Review Comments by the Colorado Geological Survey – 1/25/2024

CGS Unique No.: EP-24-0047_1 Retreat at Prairie Ridge Preliminary Plan Phase 1 (AKA Jaynes)

EP File Number: SP239, 217 SF lots and 6 rural residential lots on 108.89 acres for future residential development

The available referral documents include a Soil and Geology Study and Wastewater Study, Jaynes Property – Preliminary Plan (Entech Engineering, Job No. 212381, November 21, 2023), Preliminary Plan (Classic Consulting, December 19, 2023), Letter of Intent (N.E.S., Inc., December 2023), and other documents. Entech’s report provides a valid description of surface and subsurface conditions and soil and bedrock engineering properties. CGS offers the following comments and recommendations.

PROPOSED CUT/FILL NORTHERN RETREAT AT PRAIRIERIDGE
 POCO ROAD & VOLLMER ROAD
 EL PASO COUNTY, CO
 ELITE PROPERTIES OF AMERICA, INC.

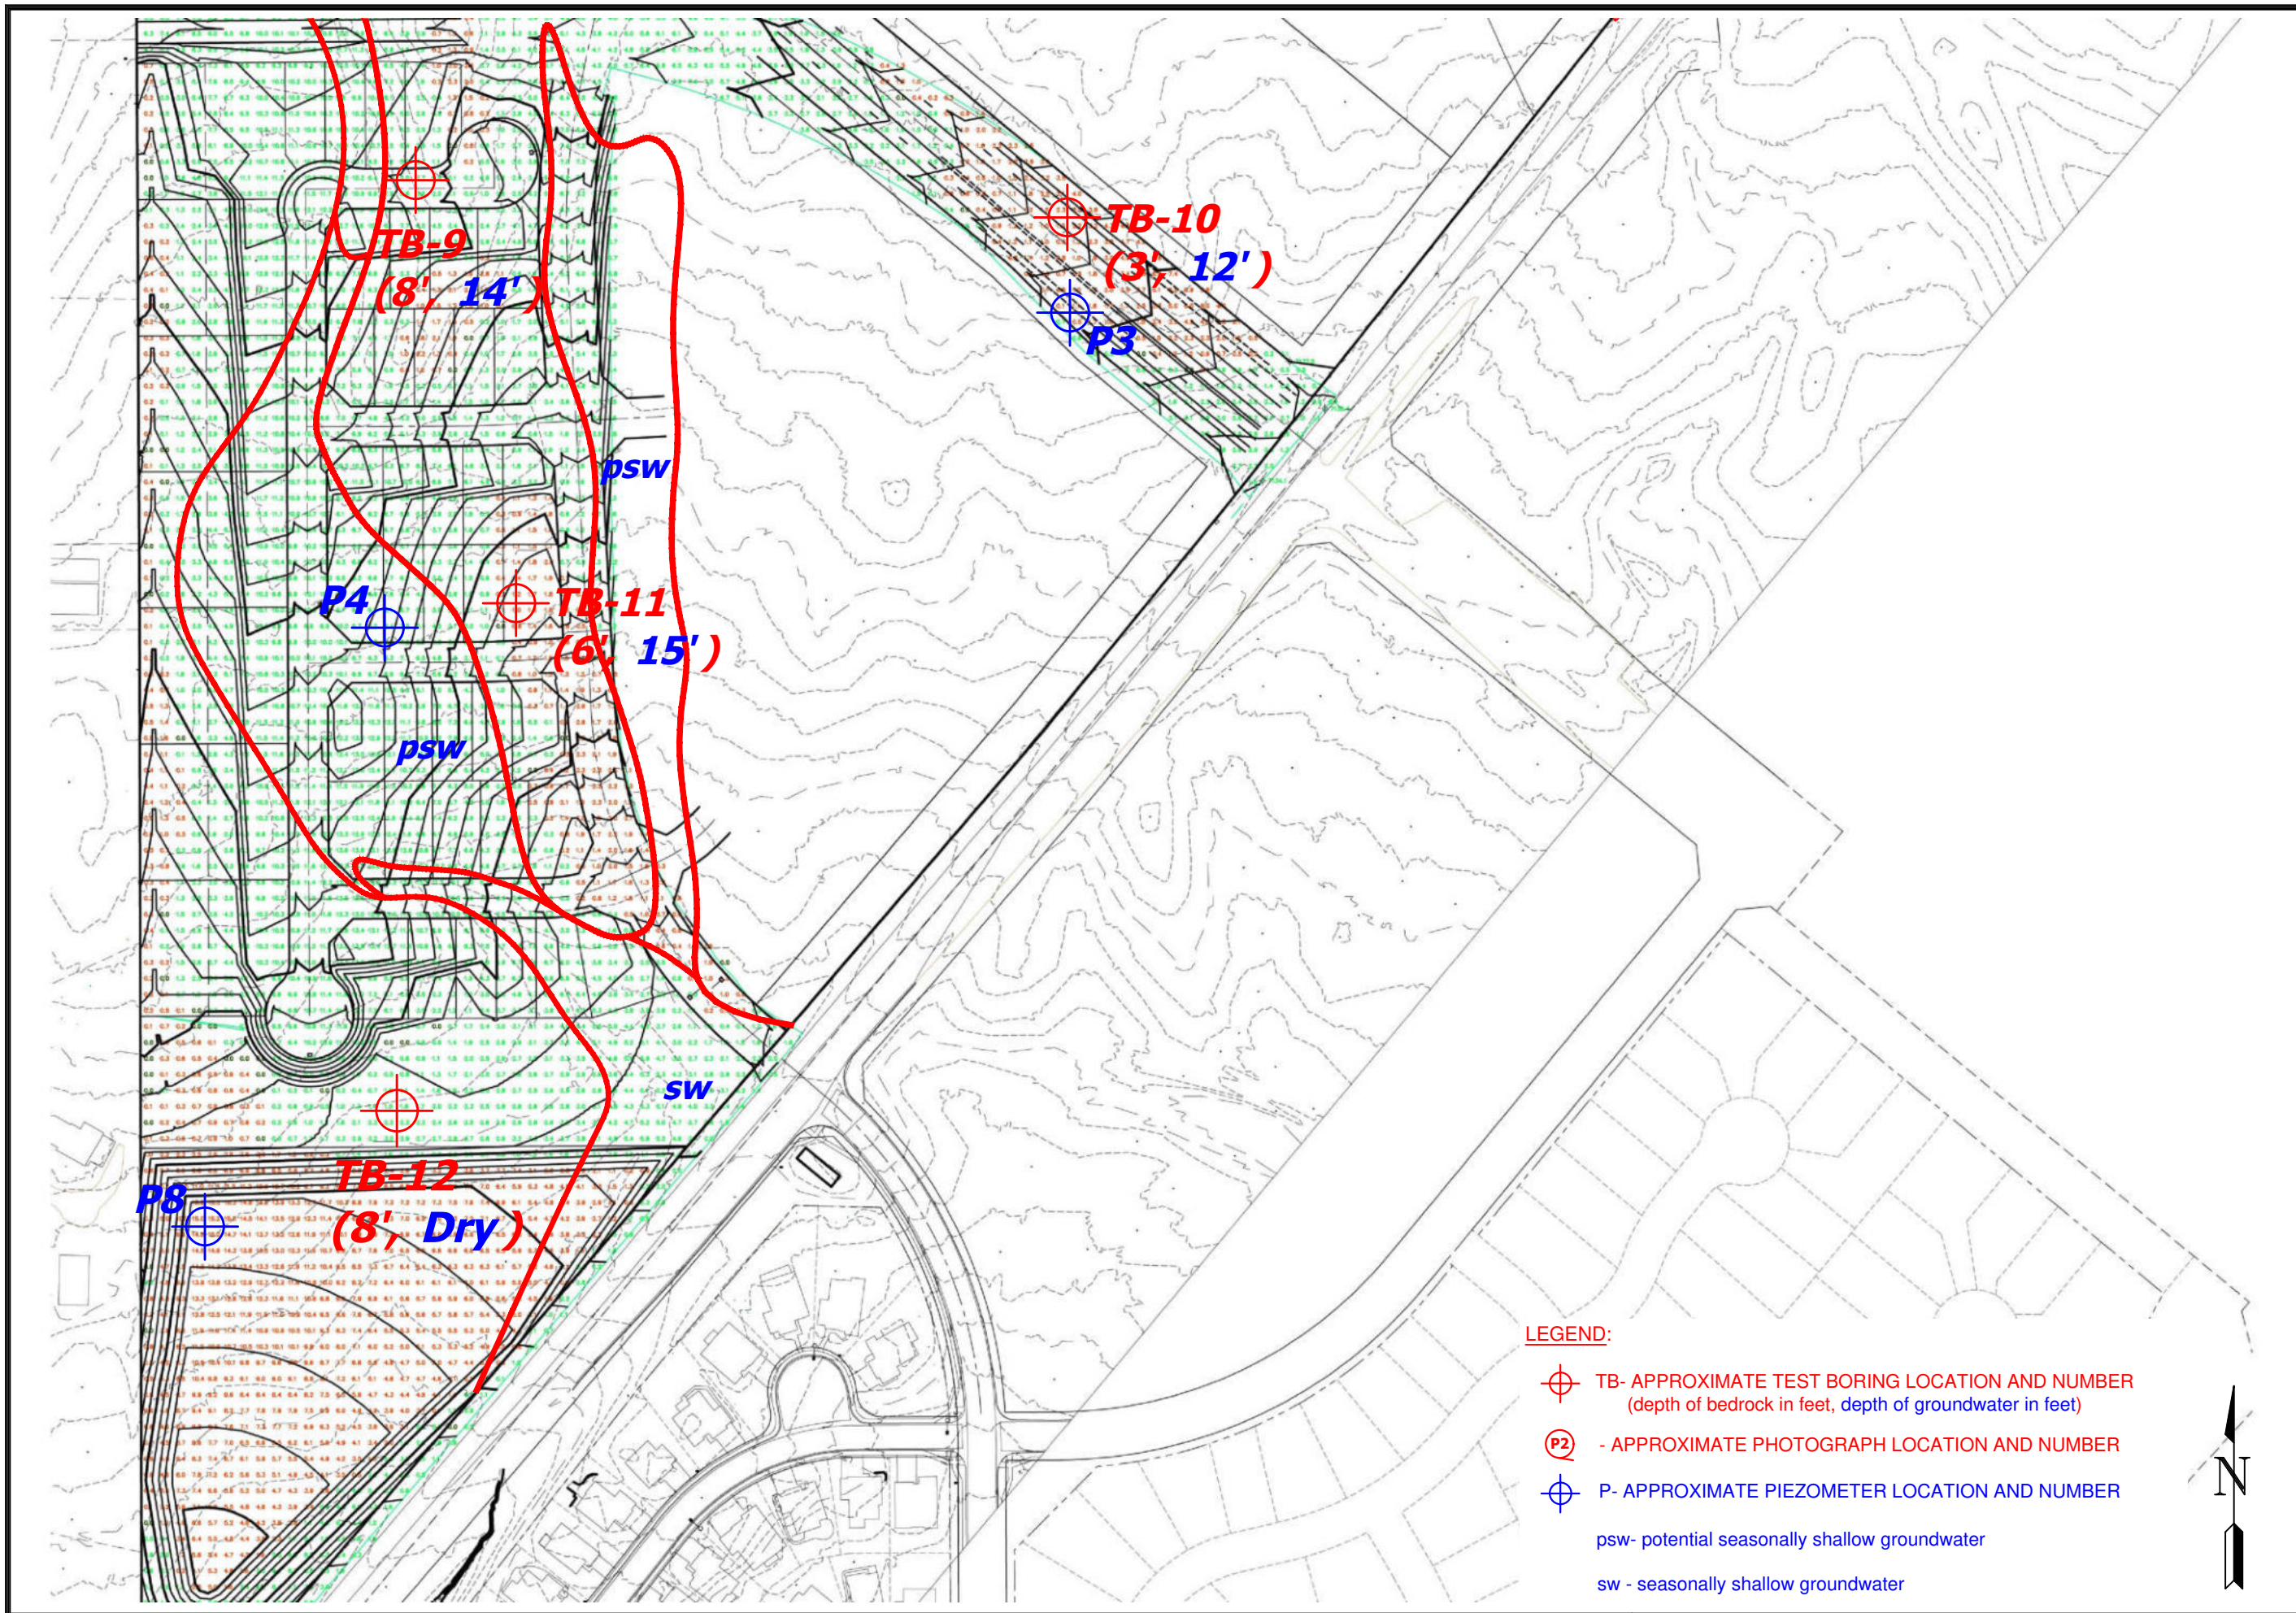
2. Entech states (page 13), “Cuts of up to 30 feet are anticipated in the north central portion of the site.” Groundwater depths in TB-2 and TB-3 are 6 and 14 feet, respectively and bedrock was encountered in the test borings at depths of 1 to 9 feet. Additionally, the test hole termination depths ranged from 12.5 to 20 feet. These conditions will significantly affect the excavation/grading operations at this site.
